App No: A/171/17/DOC

Address: Herons Farm Dappers Lane Angmering

Proposal: Application for approval of details reserved by condition planning permission A/184/15/PL relating to conditions : splays, 4- details of screen walls and/or fences, 5-surface drainage, 9-level survey, 10-landscape scheme, 11-schedl & finishes & 13- location of swallows nests.

Proposed Cottages & Stables
 Herons Farm, Dappers Lane,
 Angmering
 Scale 1:200
 Drng no 459/08

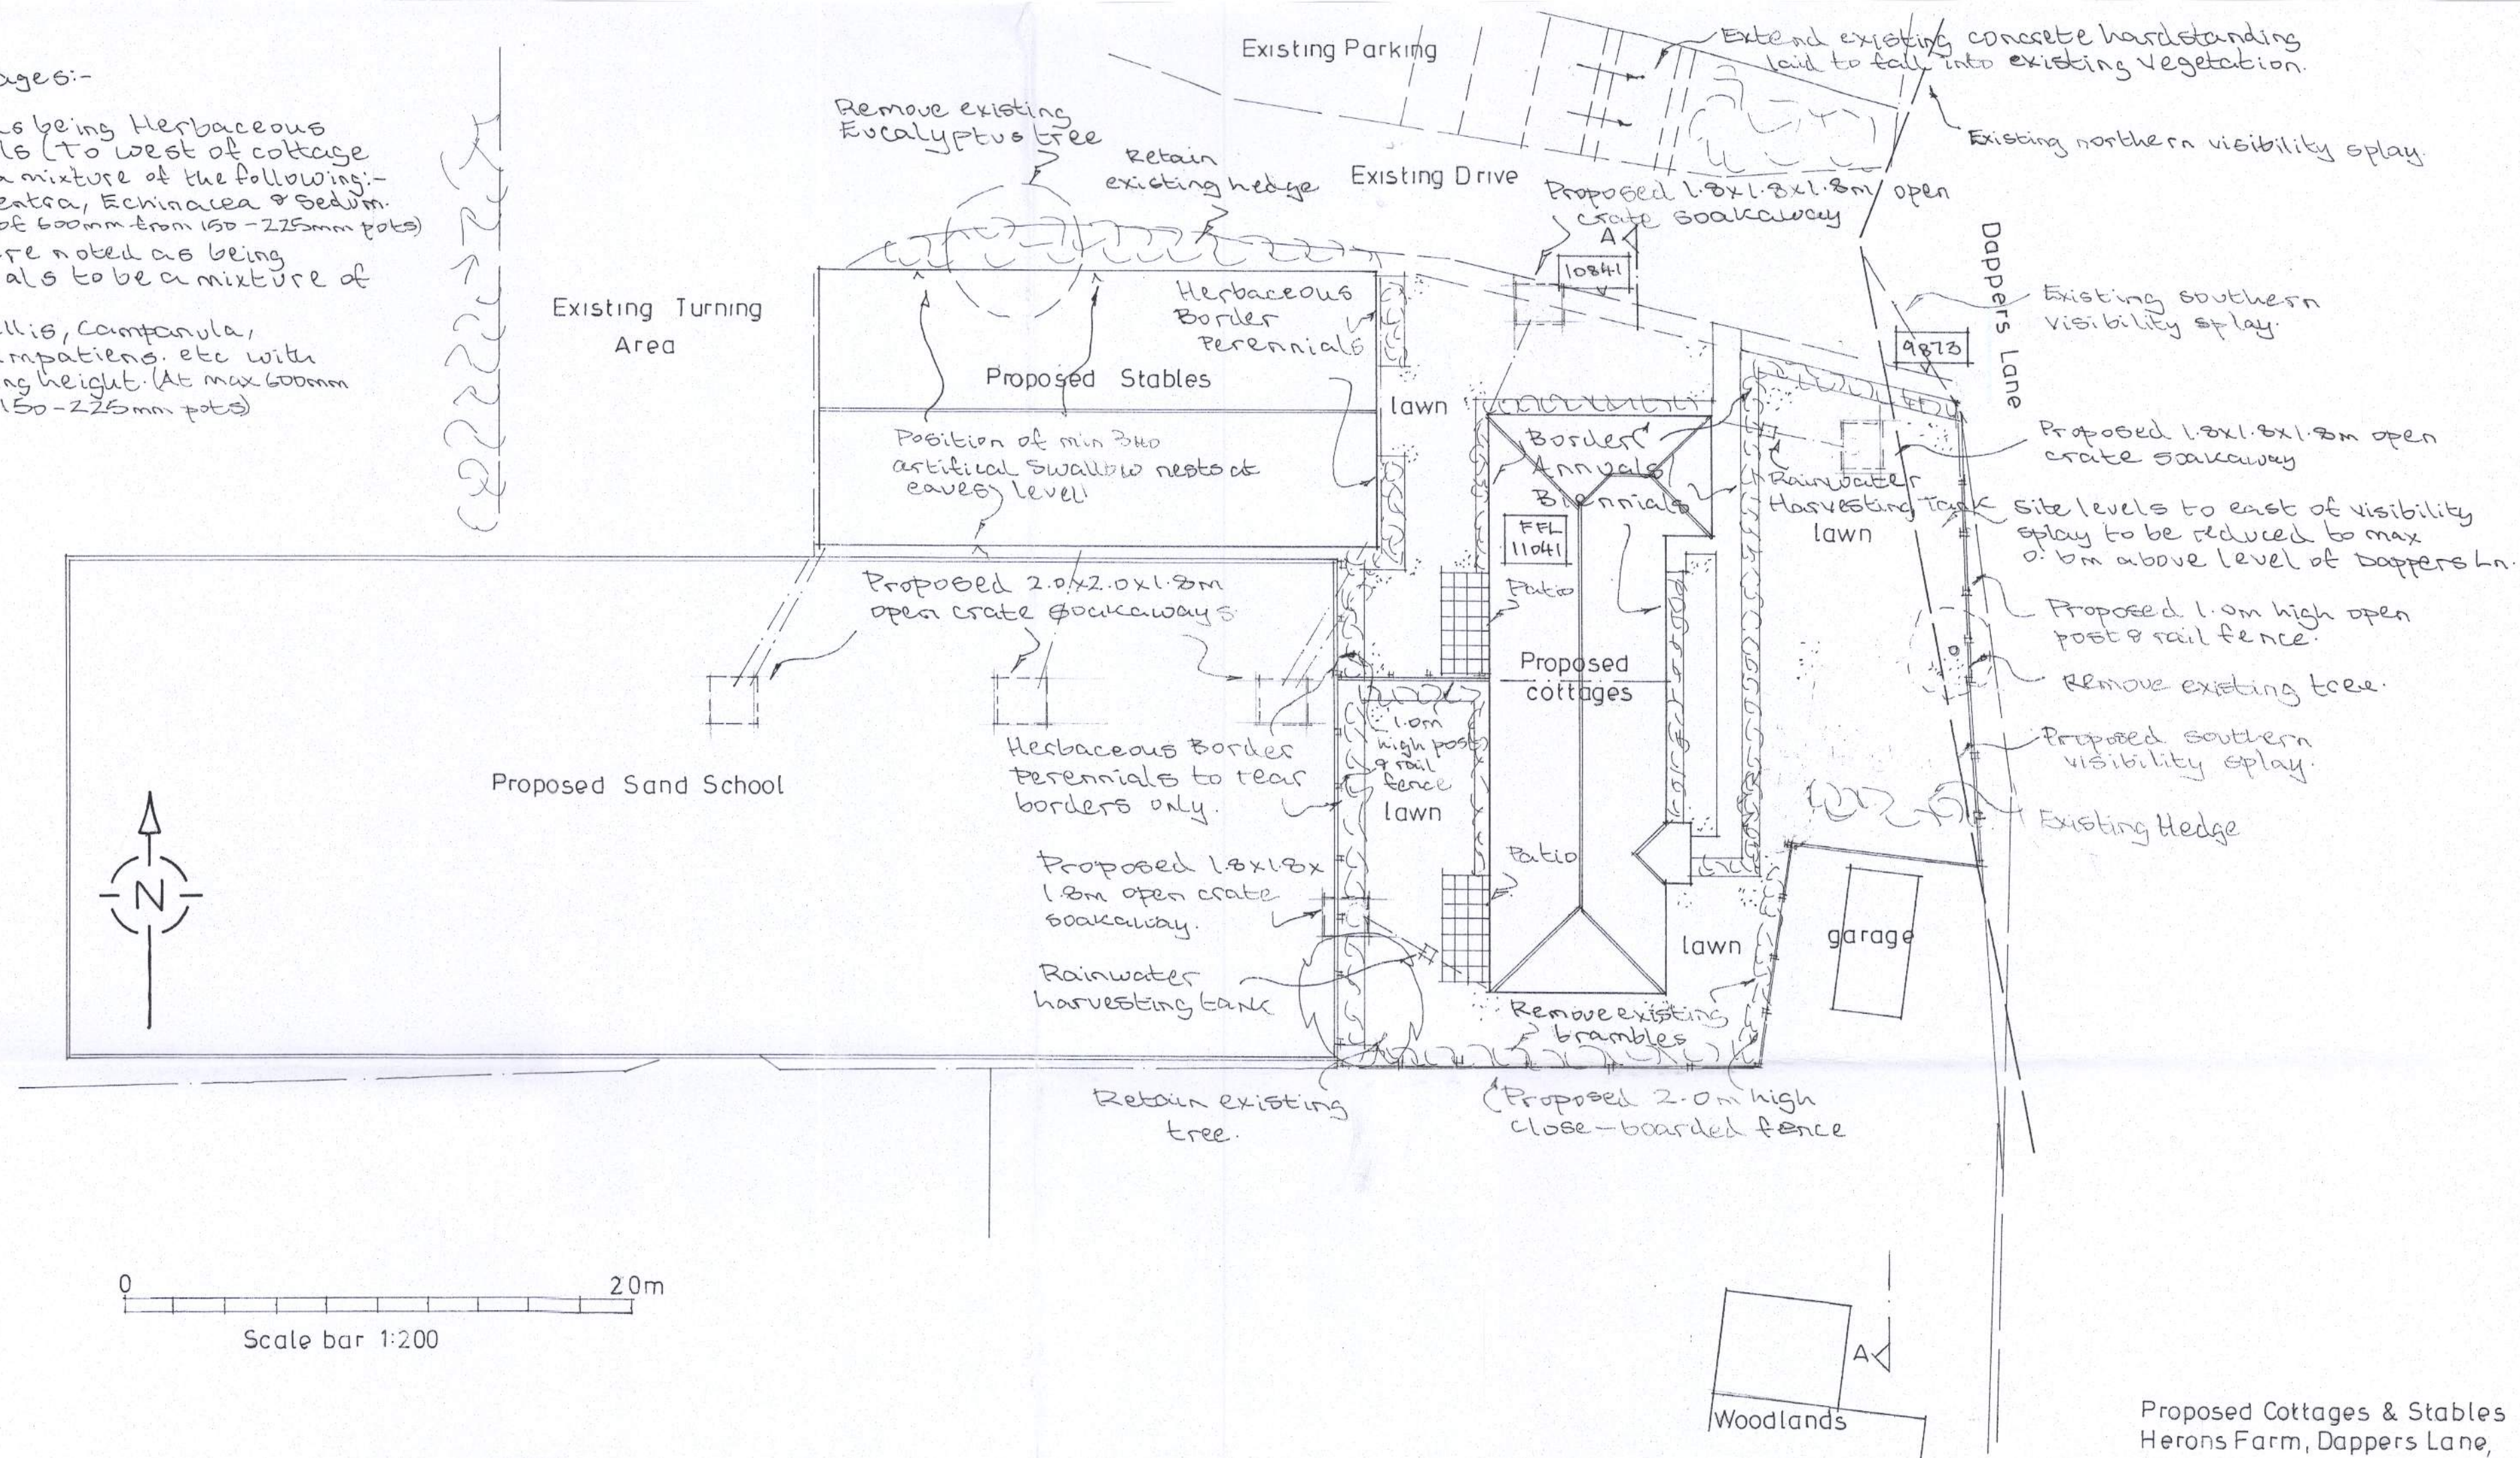
It appears that drawing 459/08 which shows the location of the swallow nests in not available on the planning portal, please can this be added so we are able to assess the DOC for this condition.
